Final Plat comment responses.pdf Markup Summary

SHEET 1 OF 3

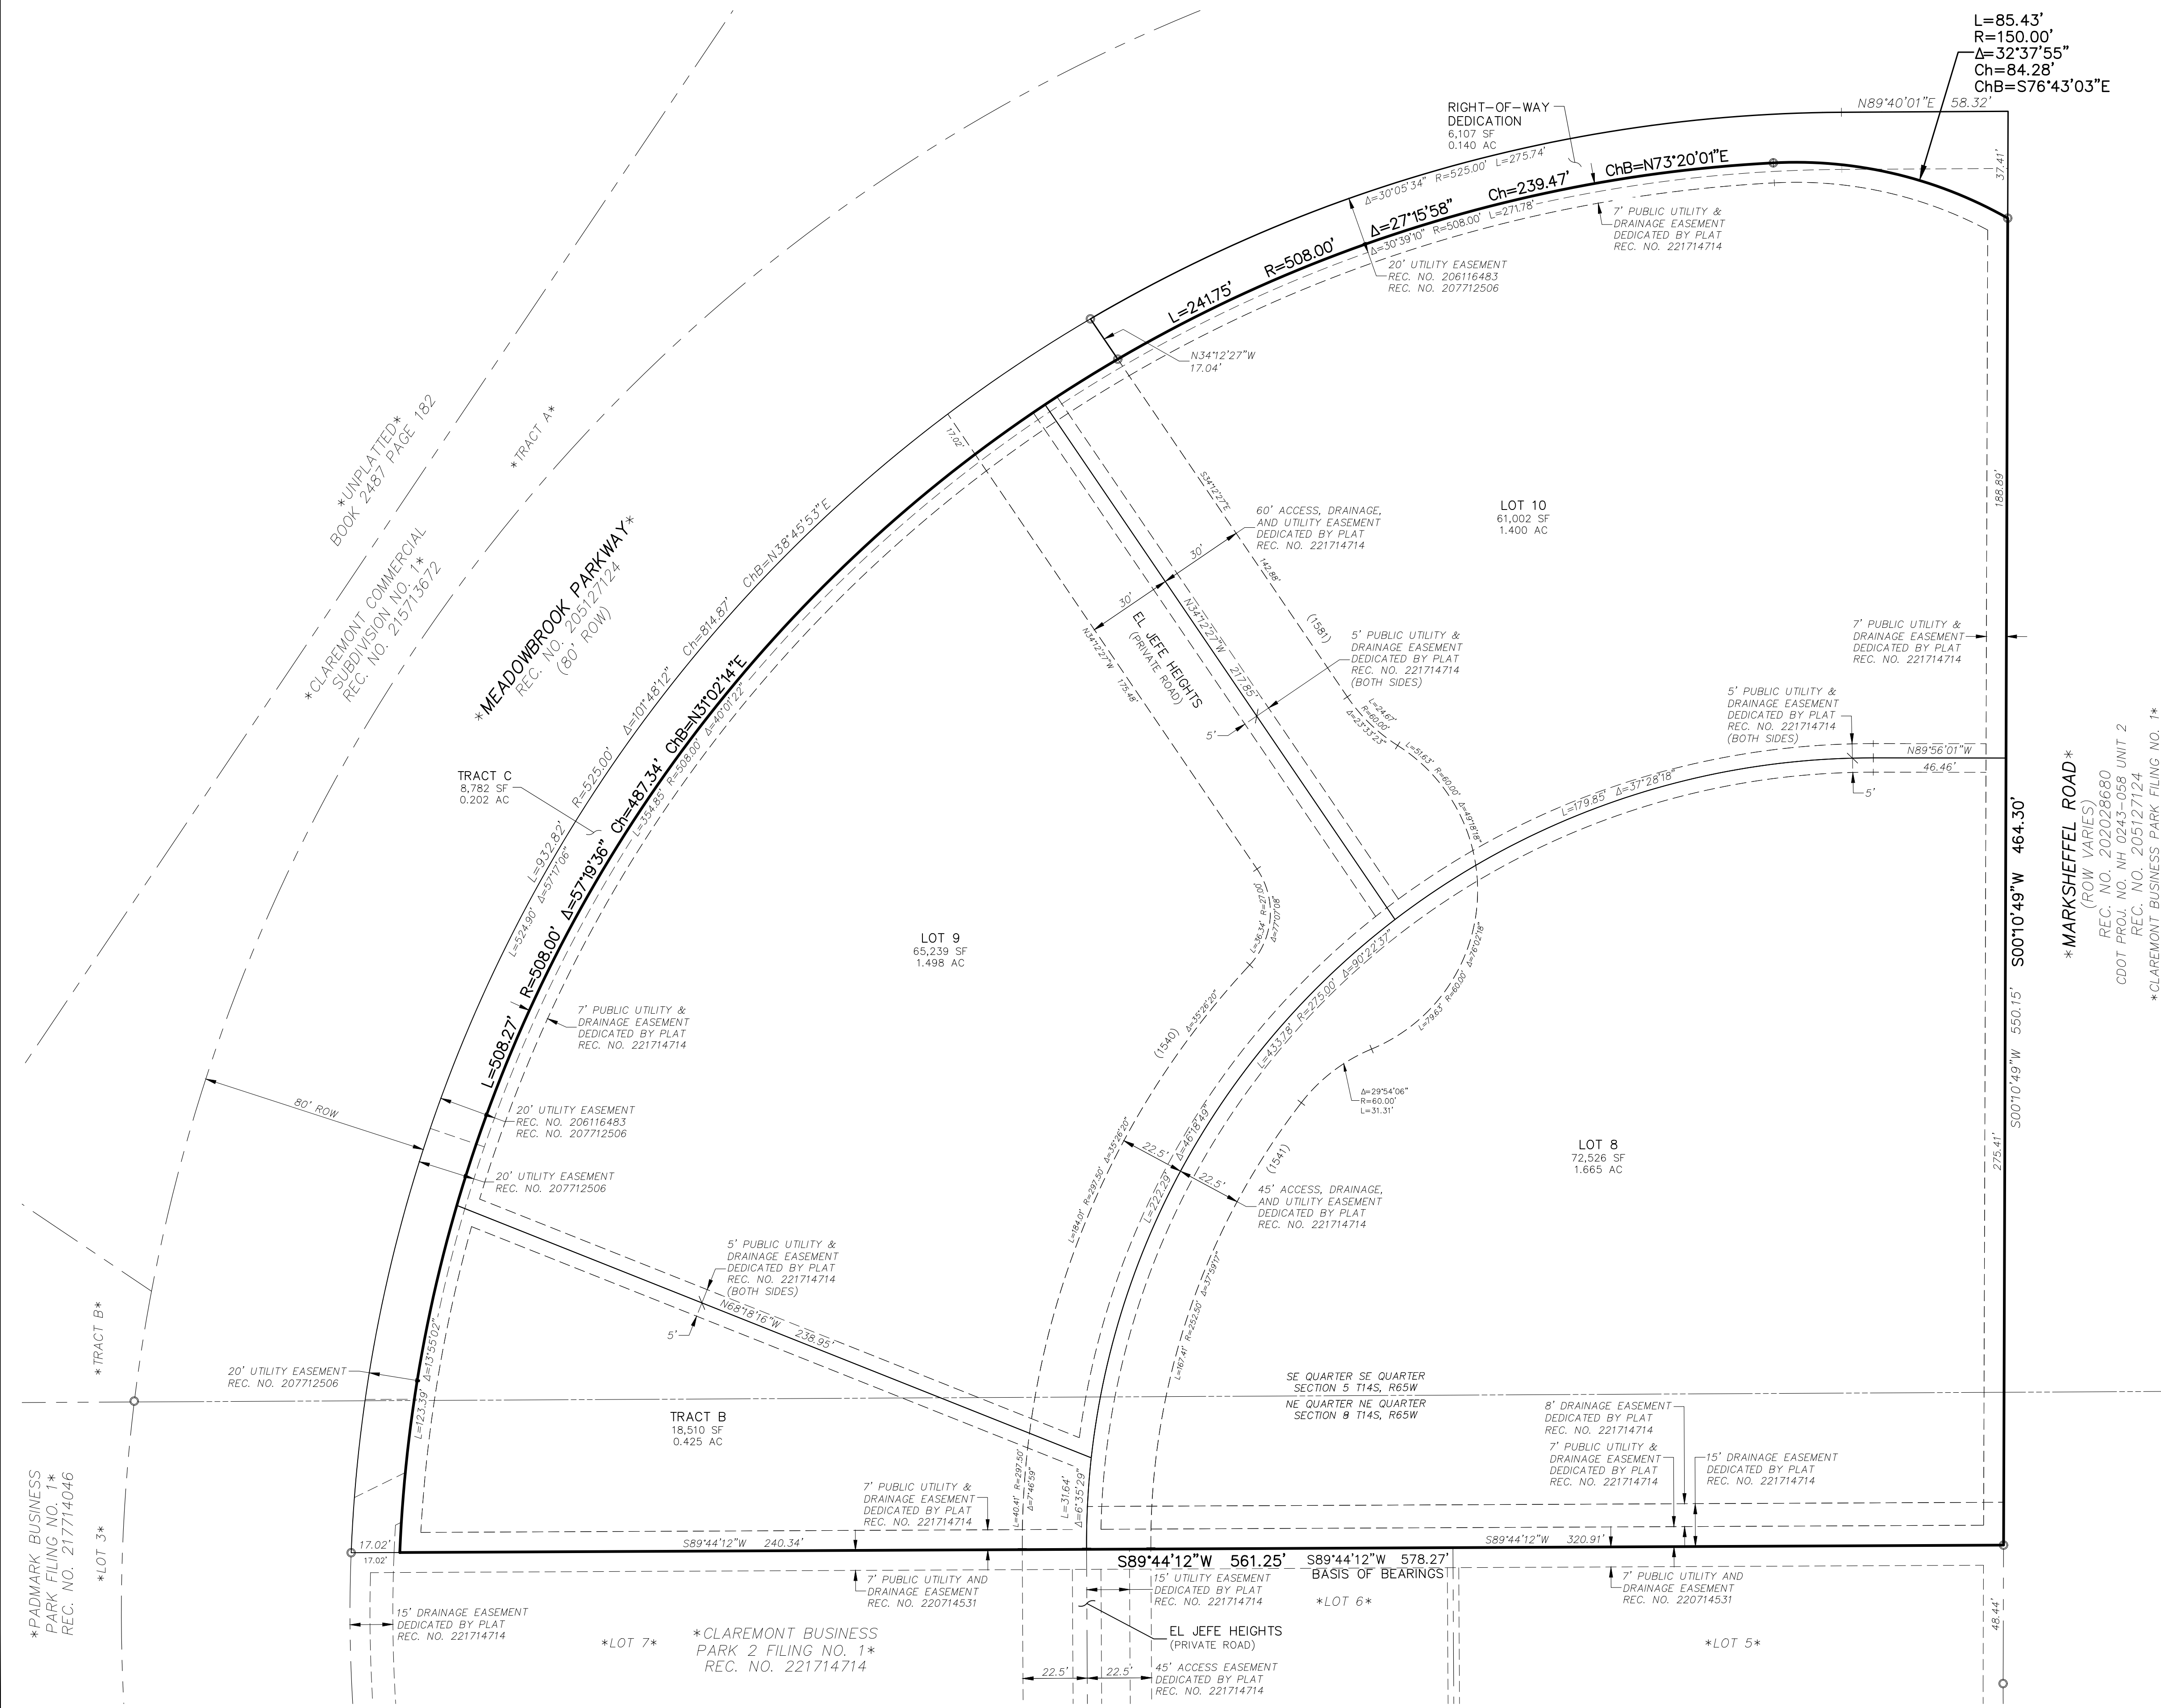
Where the Property is Located in the Airport Overlay Zone
NOTICE OF POTENTIAL AIRCRAFT OVERFLIGHT AND NOISE IMPACT ASSOCIATED WITH AIRPORT: This serves as notice of potential aircraft overflight and noise impacts on this property due to its close proximity to an airport, which is being disclosed to all prospective purchasers considering the use of this property for residential and other purposes. This property is subject to the overflight and associated noise of arriving and departing aircraft during the course of normal airport operations. (Use when this plat is to provide the notice)
All property within this subdivision is subject to a Notice of Potential Aircraft Overflight and Noise Impact recorded at Reception No. _____, of the records of the El Paso County Clerk and Recorder. (Use when the Notice has previously been recorded)
All property within this subdivision is subject to an Avigation Easement as recorded at Reception No. _____, of the records of the El Paso County Clerk and Recorder. (Use only when the property is subject to an existing avigation easement as reflected in the title policy)

Should be number 12, fix all numbers after

Unless otherwise indicated, all side, front, and rear lot lines are hereby platted on either side with a 10 foot (use 5 feet for lots smaller than 2.5 acres) public utility and drainage easement unless otherwise indicated. All exterior subdivision boundaries are hereby platted with a 20 foot (use 7 feet for lots smaller than 2.5 acres) public utility and drainage easement. The sole responsibility for maintenance of these easements is hereby vested with the individual property owners.

Subject: Owner Certification
Page Label: Sheet 1 - Cover
Author: Kylie Bagley
Date: 3/29/2023 12:50:32 PM
Status:
Color: ■
Layer:
Space:

The undersigned, being all the owners, mortgagees, beneficiaries of deeds of trust and holders of other interests in the land described herein, have laid out, subdivided, and platted said lands into lots, tracts, streets, and easements (use which are applicable) as shown hereon under the name and subdivision of

_____. All public improvements so platted are hereby dedicated to public use and said owner does hereby covenant and agree that the public improvements will be constructed to El Paso County standards and that proper drainage and erosion control for same will be provided at said owner's expense, all to the satisfaction of the Board of County Commissioners of El Paso County, Colorado. Upon acceptance by resolution, all public improvements so dedicated will become matters of maintenance by El Paso County, Colorado. The utility easements shown hereon are hereby dedicated for public utilities and communication systems and other purposes as shown hereon. The entities responsible for providing the services for which the easements are established are hereby granted the perpetual right of ingress and egress from and to adjacent properties for installation, maintenance, and replacement of utility lines and related facilities.

Name, address and telephone number of the owner of record located in the lower right hand corner

Deviation

Deviation

Airport Overlay Zone note revised.

Plat note sequencing error corrected.

All lots are smaller that 2.5 acres, so the 5 foot and 7 foot widths as indicated in the easement note are correct.

Verbiage changed as requested.

Verbiage changed as requested.

Owners Certificate verbiage revised. As there is only a single owner, references to mortgagees and other interest holders were not added. As the owner is not a corporation, "Attest" was not included. It is possible that this plat may be sent out of state for signatures, so the reference to Colorado in the notarial was omitted.

File number added to all sheets.

Verbiage changed as requested.

Verbiage changed as requested.

SHEET 2 OF 3

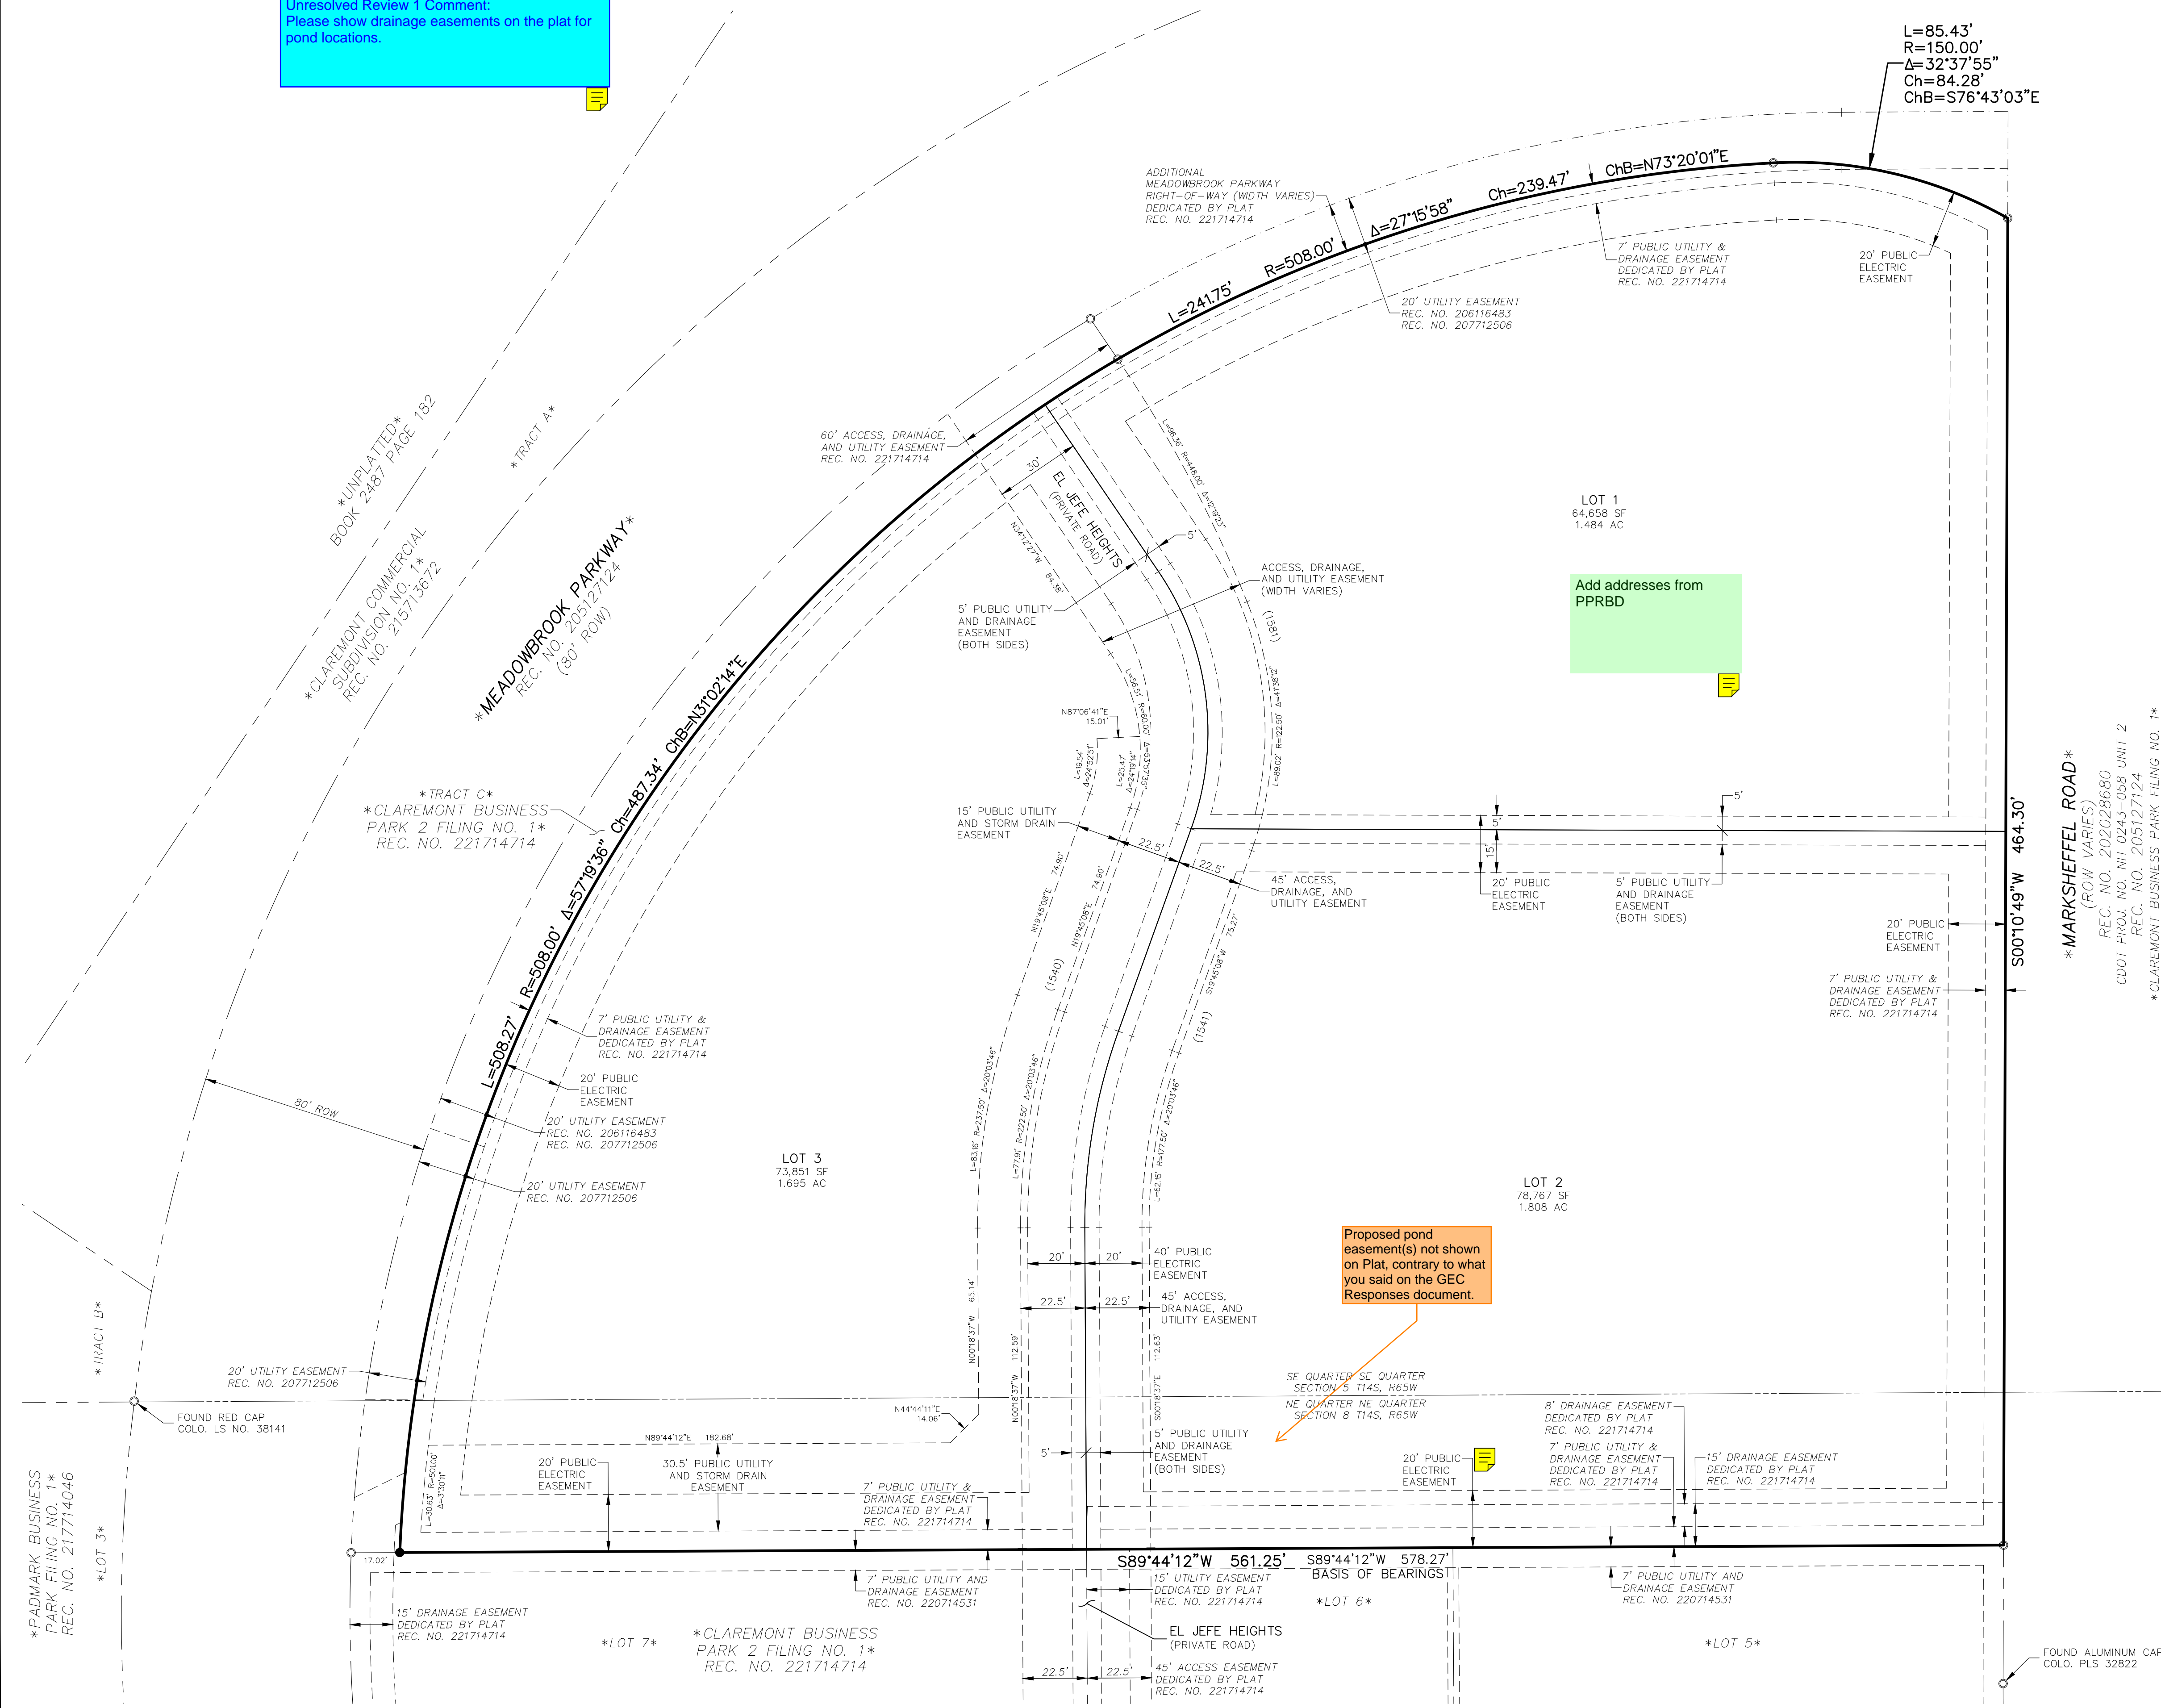
The scale shall be one inch equals 100 feet (1inch = 100 feet) or a scale of one inch equals 50 feet (1 inch = 50 feet) unless the PCD Director approves a larger or smaller scale.

A request for scale variance will be made.

AS REPLATTED

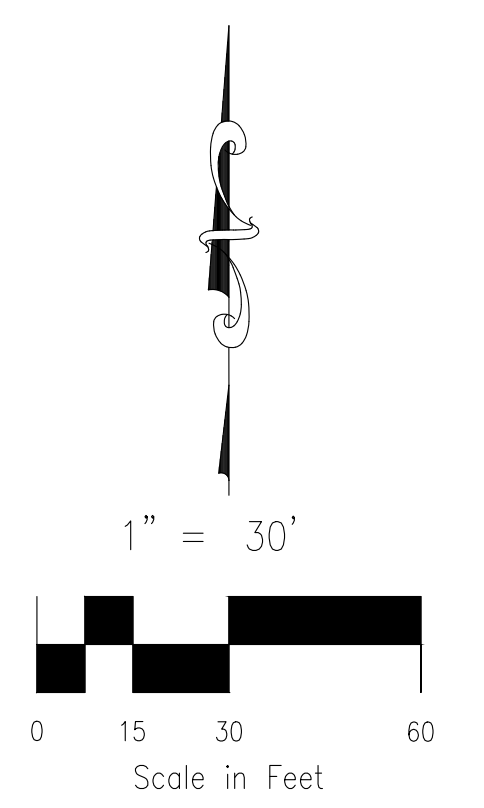
Show drainage easements for the locations of the ponds

The scale shall be one inch equals 100 feet (1inch = 100 feet) or a scale of one inch equals 50 feet (1 inch = 50 feet) unless the PCD Director approves a larger or smaller scale.

A request for scale variance will be made.
